April 24, 2023

**RE: Undi Commerce Park**

The responses below correlate to the numbered review comments on your letter dated April 27, 2022.

**SHEET**  
C9 of C13

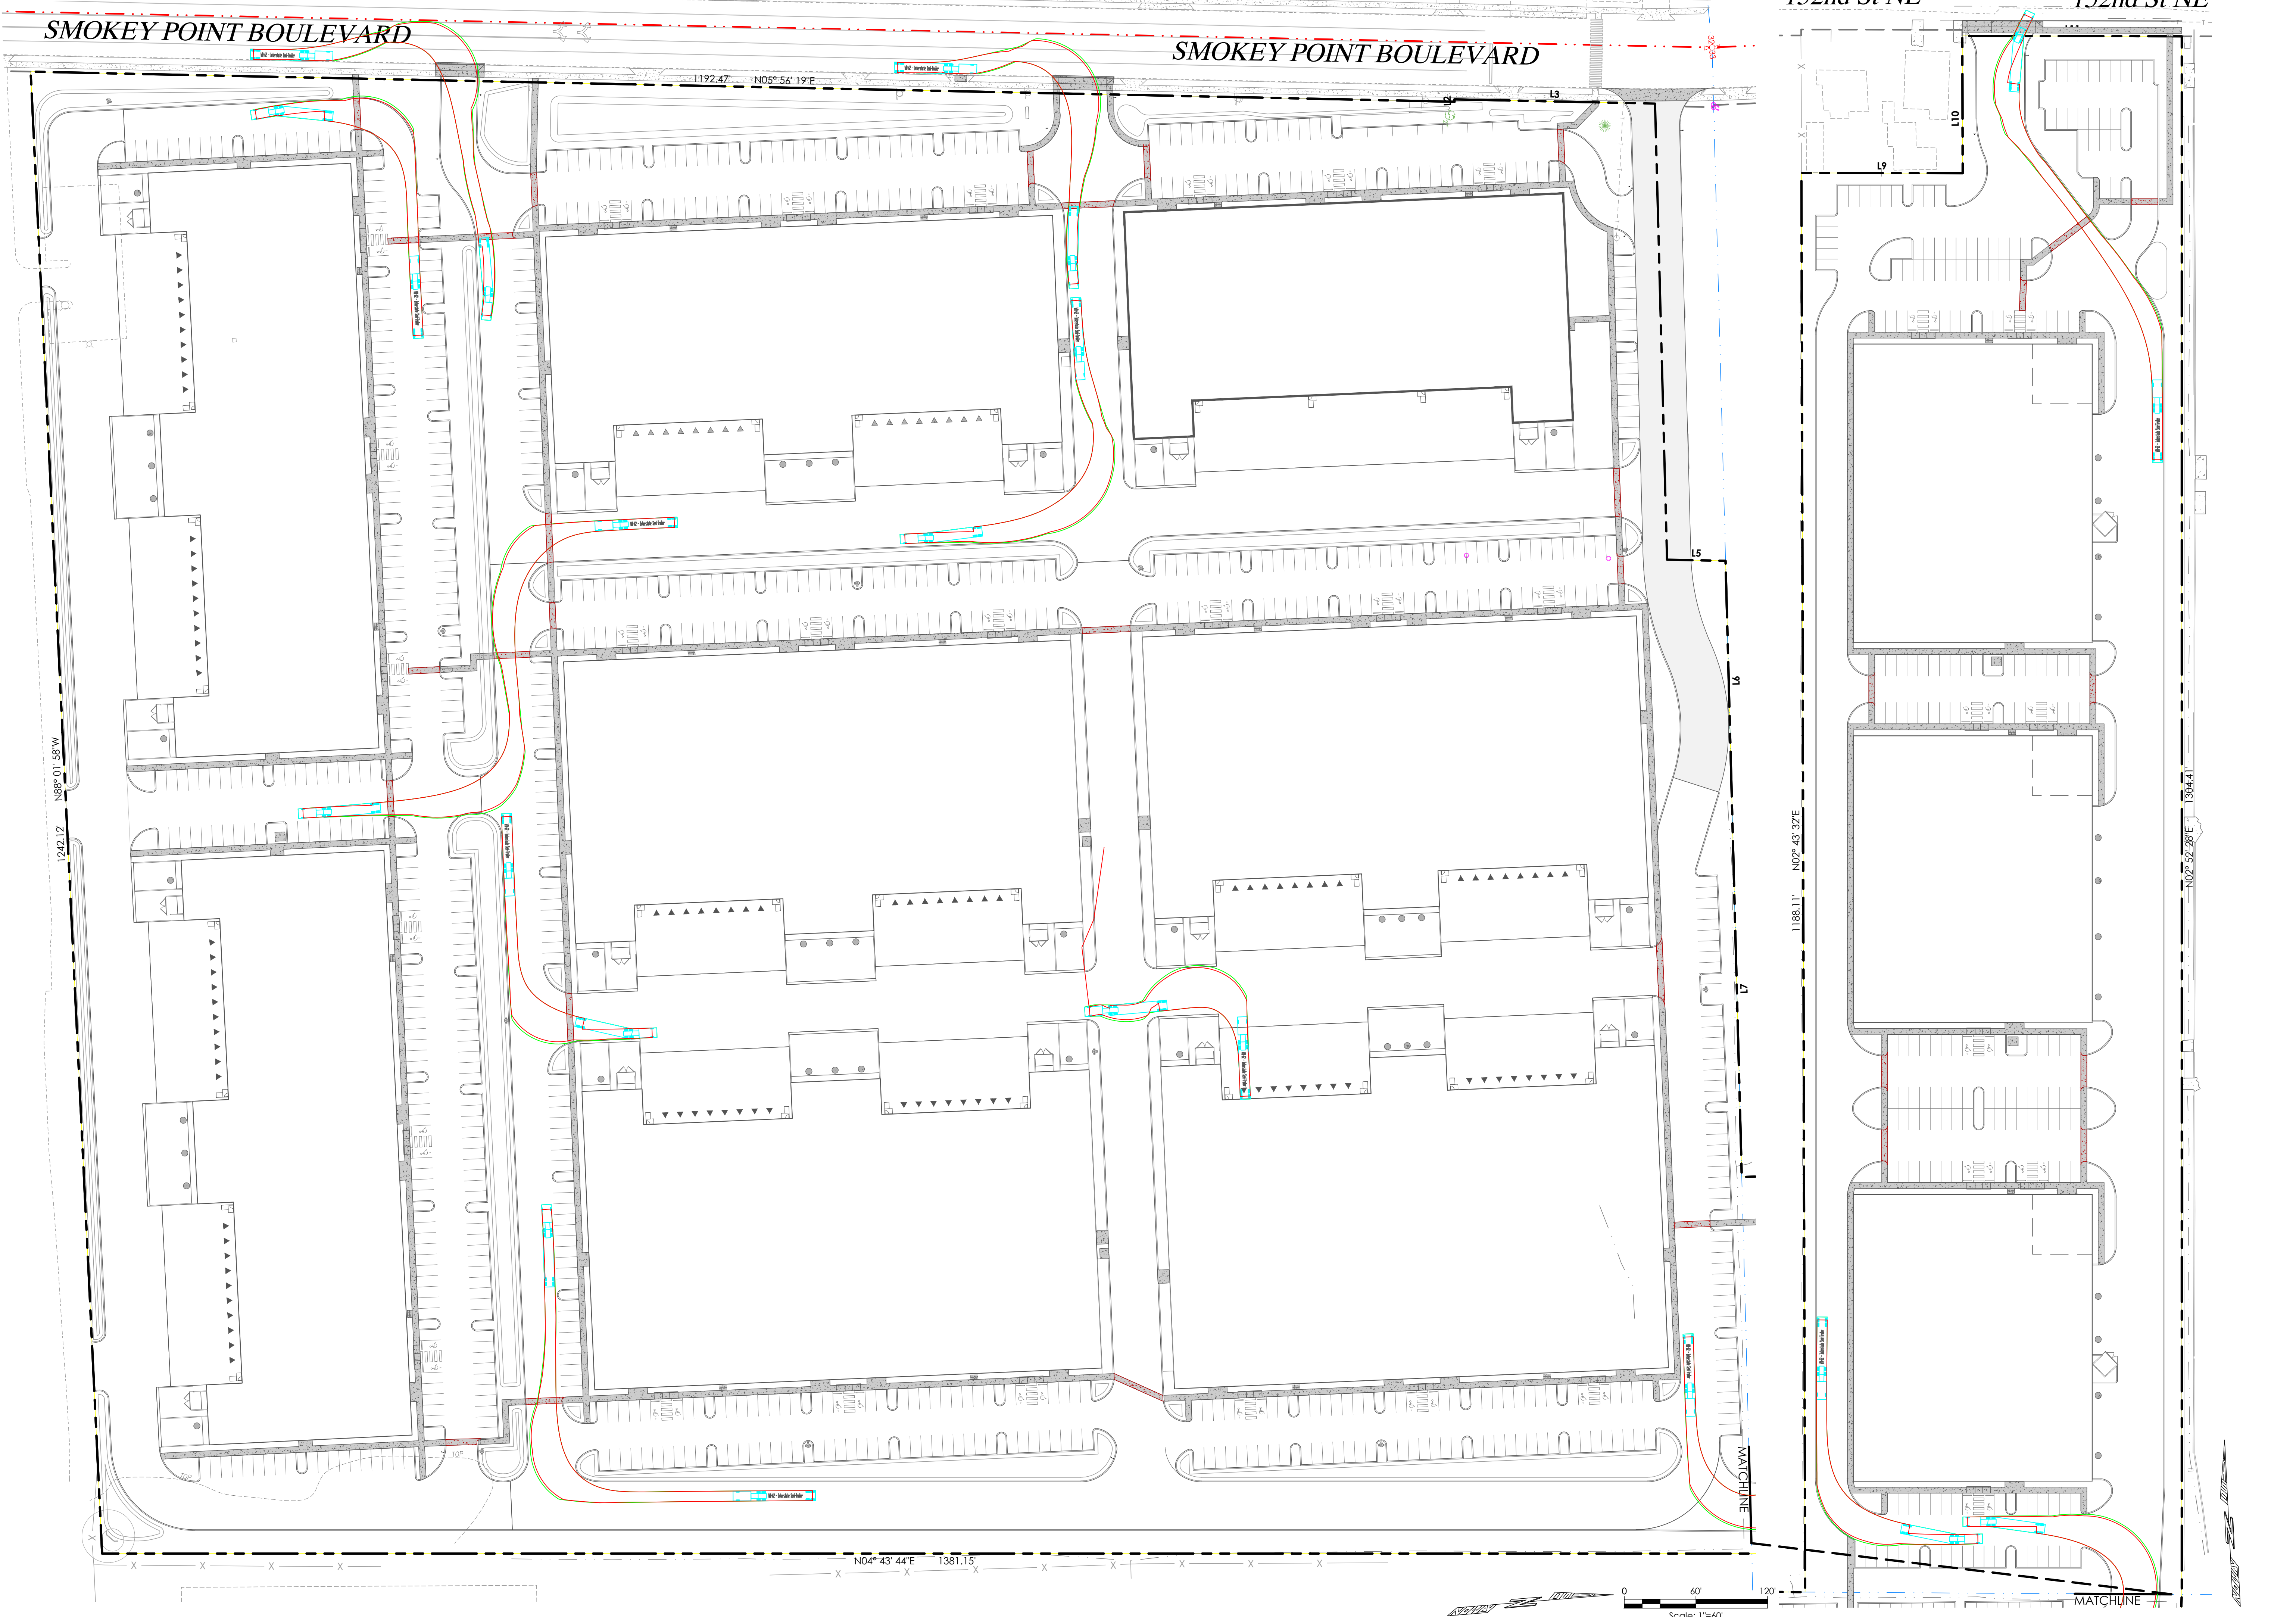
- 5d. Same response as 5c above.
- 5e. Typical turn radius shown on sheet C1.
- 5f. Auto turn exhibit is shown on sheet C9.
- 5g. Pedestrian connections have been added to the site plan per the marked-up plans provided in review #1. All buildings are interconnected, and access is provided at multiple locations along 152<sup>nd</sup> Street NE and Smokey Point Boulevard. Pedestrian access through all drive aisles will be concrete with a decorative pattern. See sheets A1.1-A1.3.
